Office of Environment & Heritage

RE: ENVIRONMENTAL ASSESSMENT FOR DALTON POWER PROJECT (MP10_0035)

**OFFICE OF ENVIRONMENT AND HERITAGE
COMMENTS AND RECOMMENDATIONS
ENVIRONMENTAL ASSESSMENT FOR THE PROPOSED DALTON POWER PROJECT**

Figure 3-1 TAPM Generated Annual Wind rose for the proposed site (2006)

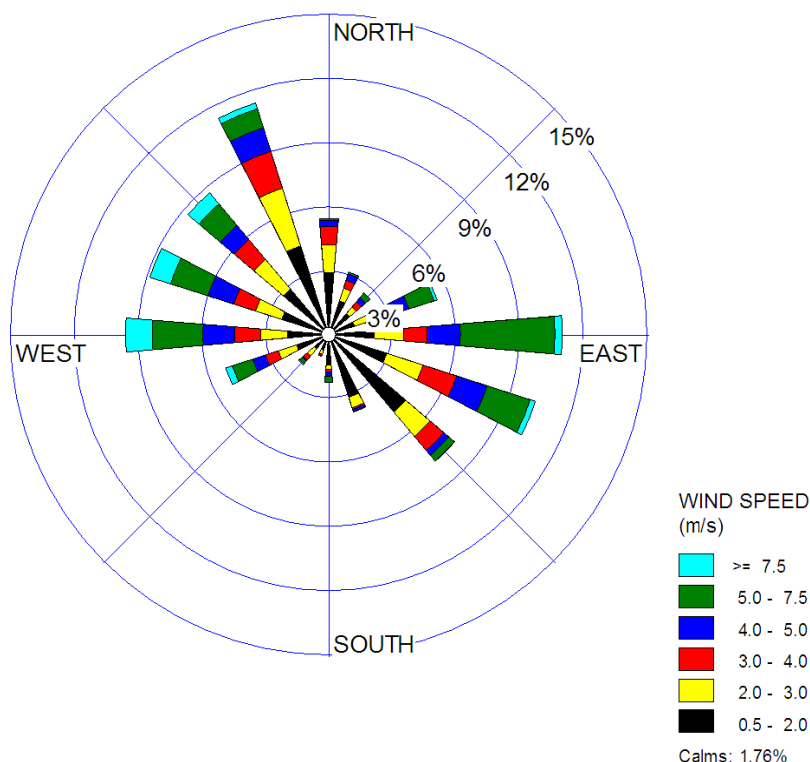
- In our adequacy review, OEH noted that the use of TAPM meteorological data in noise assessment has been known to underestimate the occurrence of conditions most likely to enhance noise propagation (inversions and low wind speeds). OEH recommended that the proponent demonstrate that this potential underestimation is not occurring by presenting cumulative distribution functions of wind speeds for the TAPM-generated "site" data versus cumulative distribution functions of wind speeds from surrounding "real" meteorological stations. This information does not appear to have been included in the exhibited NIA, therefore unless the proponent provides further information regarding the occurrence of inversions, OEH has included by way of the suggested conditions below that the noise limits apply under all Stability Class temperature inversions conditions, including G class.

L6.3 The noise limits set out in condition L6.1 apply under all meteorological conditions (including all stability class temperature inversions) except for wind speeds greater than 3 metres/second at 10 metres above ground level.

- The data to be used for determining meteorological conditions is the data recorded by the meteorological weather station established at the site for the purposes of this Environment Protection Licence and identified as EPA Identification Point A
- Temperature inversion conditions (stability category) are to be determined by the sigma-theta method referred to in Part E4 of Appendix E to the NSW Industrial Noise Policy.

M7.1 A meteorological weather station must be established and maintained at the site so as to be capable of continuously monitoring the parameters specified in condition M7.2.
